Reference Number: 6/2022/2300/COND

DESCRIPTION: Submission of details pursuant to condition numbers - 1 (Construction Management Plan), 5 (Surface Water Strategy), 6 (Surface Water Scheme), 7 (Drainage), 8 (Foundation), 9 (Design Plan), 10 (Accessible Housing Scheme), 11 (Highway Improvement), 12 (Samples), 13 (Hard Landscaping), 14 (Soft Landscaping), 15 (Hard landscaping - roof garden), 16 (external lighting), 17 (Cycle Store), 18 (Cycle Store under-croft/Open air), 19 (Balcony Screens), 20 (Energy & Sustainability Statement), 21 (PV Cells Plan), 22 (Bat & Bird Boxes), 23 (Noise Compliance), 24 (Noise Compliance), 26 - (SuDS), 27 (Access), 28 (EV Charging Points), 29 (Parking), 30 (Bin Stores), 31 (Roof Gardens), on planning permission 6/2020/3222/MAJ

LOCATION: Beadles Volkswagen Van Centre, Harpsfield Broadway, Hatfield, AL10 9TF

We have reviewed the additional comments referenced 012150 – DES-Volkswagen Hatfield that were supplied on 2nd December 2022 and provides additional details addressing conditions 8 and 22. Our response will only consider the remarks referring to condition 8.

Figure 4: Bore Hole 1 (BH1)- Showing Strategy with Piling Profile

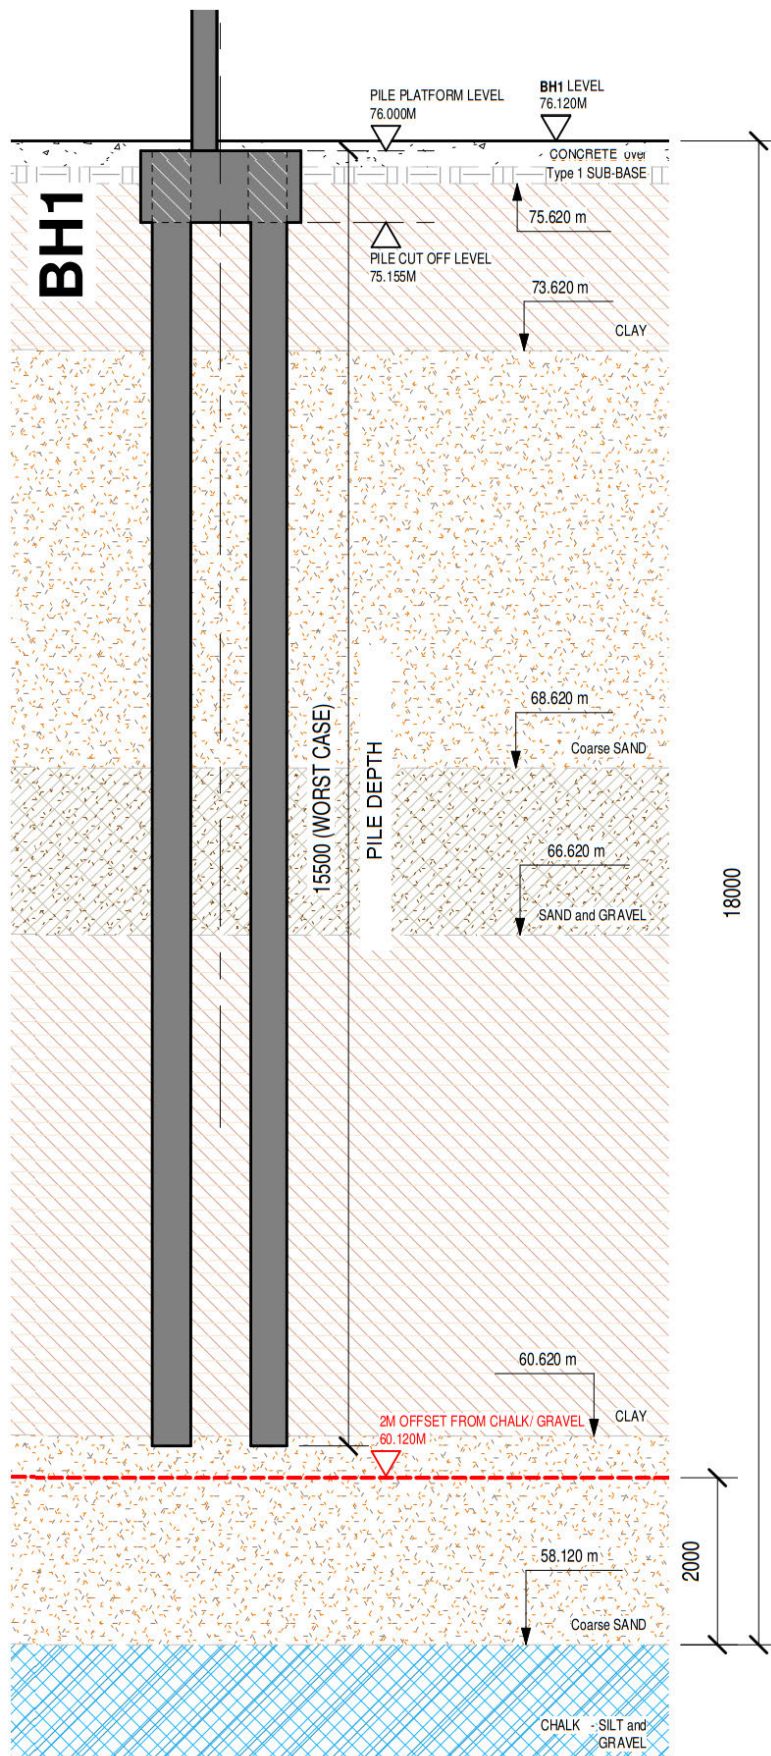
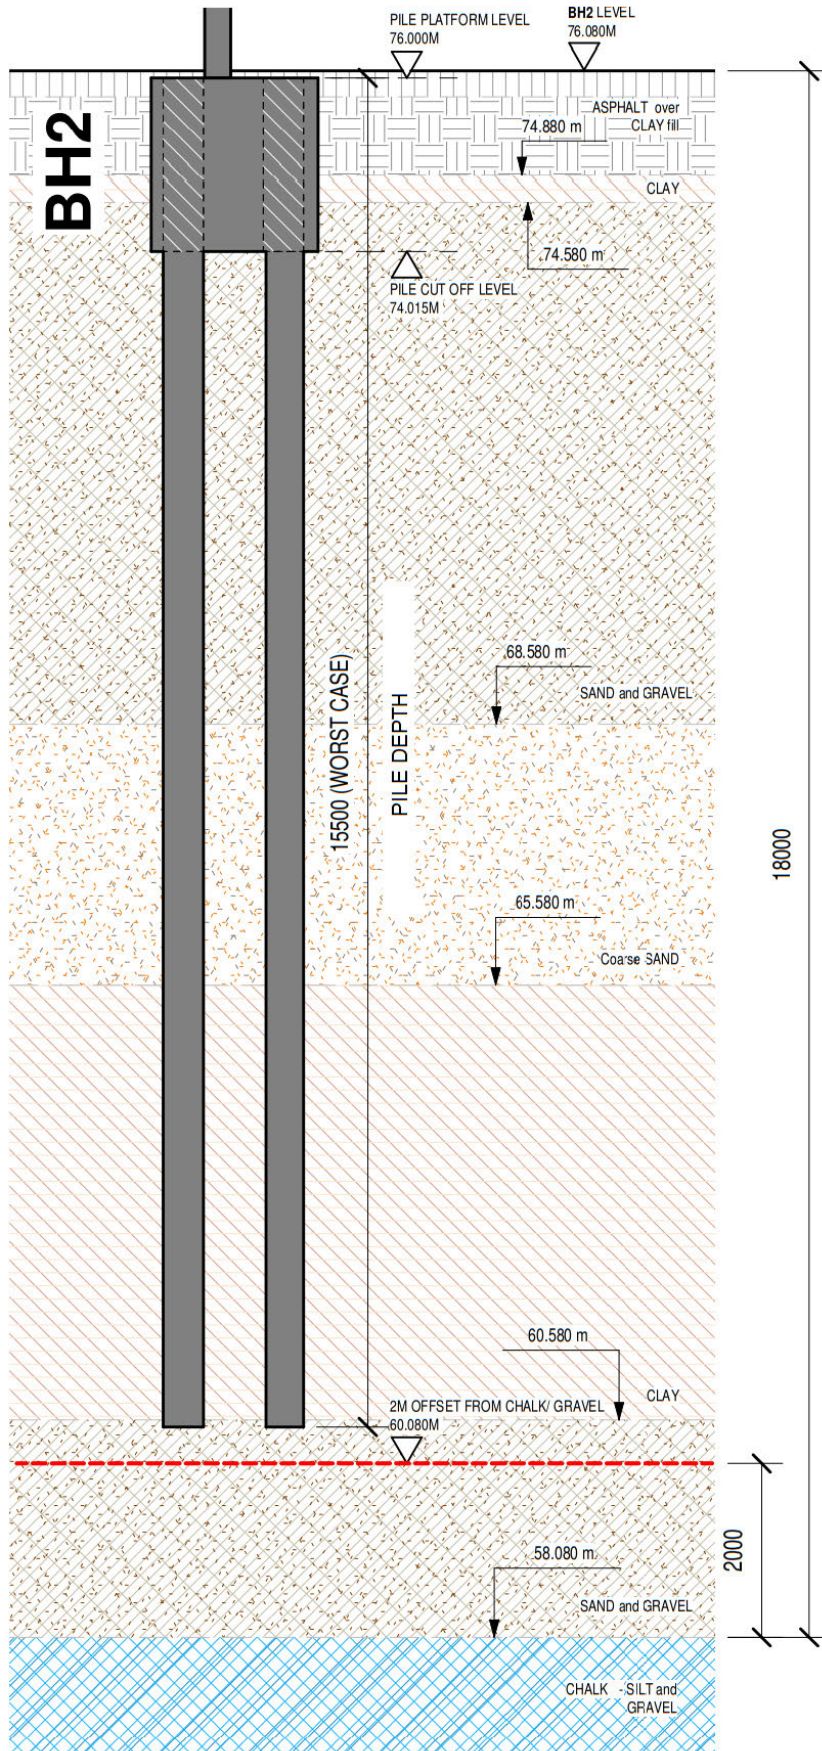
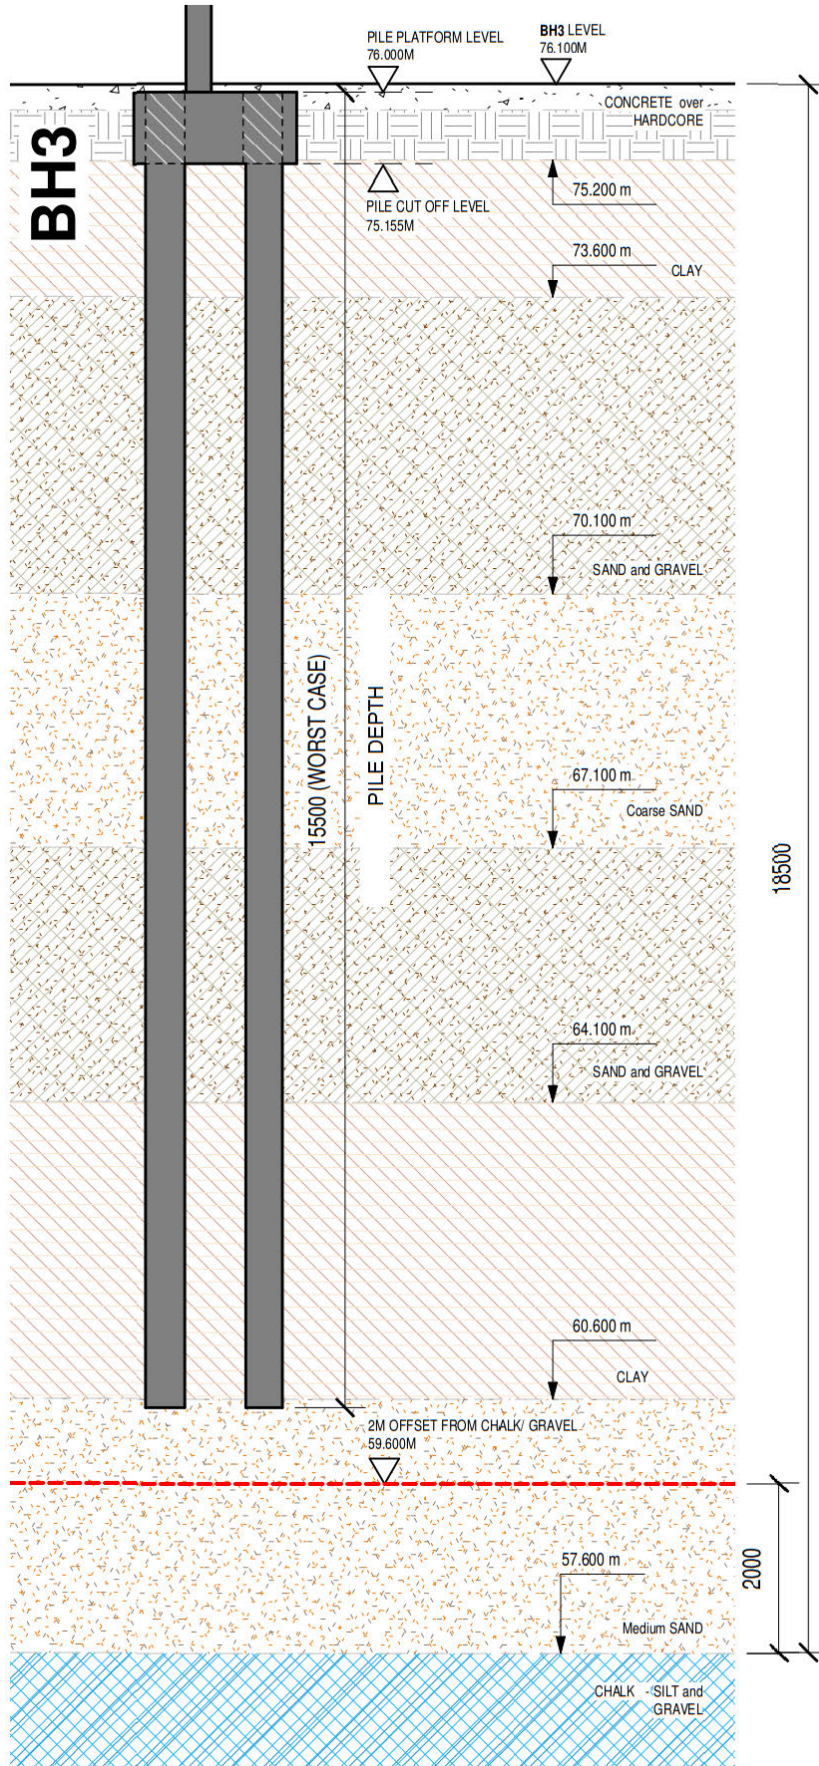
Affinity Water continues to hold its **objection** to condition 8 and this is due to the piling depth mentioned in the supporting document.

Our concern as mentioned in our initial response (dated 1st November 2022) is that the proposed piling depth finishes at the top of the Lower Sand and Gravel aquifer which is hydraulically connected with the Chalk aquifer below (principal aquifer). These geological units have recorded elevated levels of Bromate linked to historic contamination which is currently controlled by scavenging activity undertaken by Affinity Water. The piling depth proposed will penetrate the Boulder Clay layer that separates the Upper Gravel aquifer (secondary aquifer) from the Lower Gravels and Chalk, potentially creating a pathway that would hydraulically link the two aquifers allowing the Bromate to bypass active scavenging activities and affect local third-party groundwater abstractions (from the secondary aquifer) and groundwater-dependent ecosystems.

In order to consider removal of our objection of condition 8, we would require that piling does not exceed a depth below 62mAOD (a minimum of 2m above the base of the Boulder Clay, based on the limited information available from the two onsite boreholes). We expect

that once the piling method statement has been updated, we would get the opportunity to review prior to discharging condition 8.
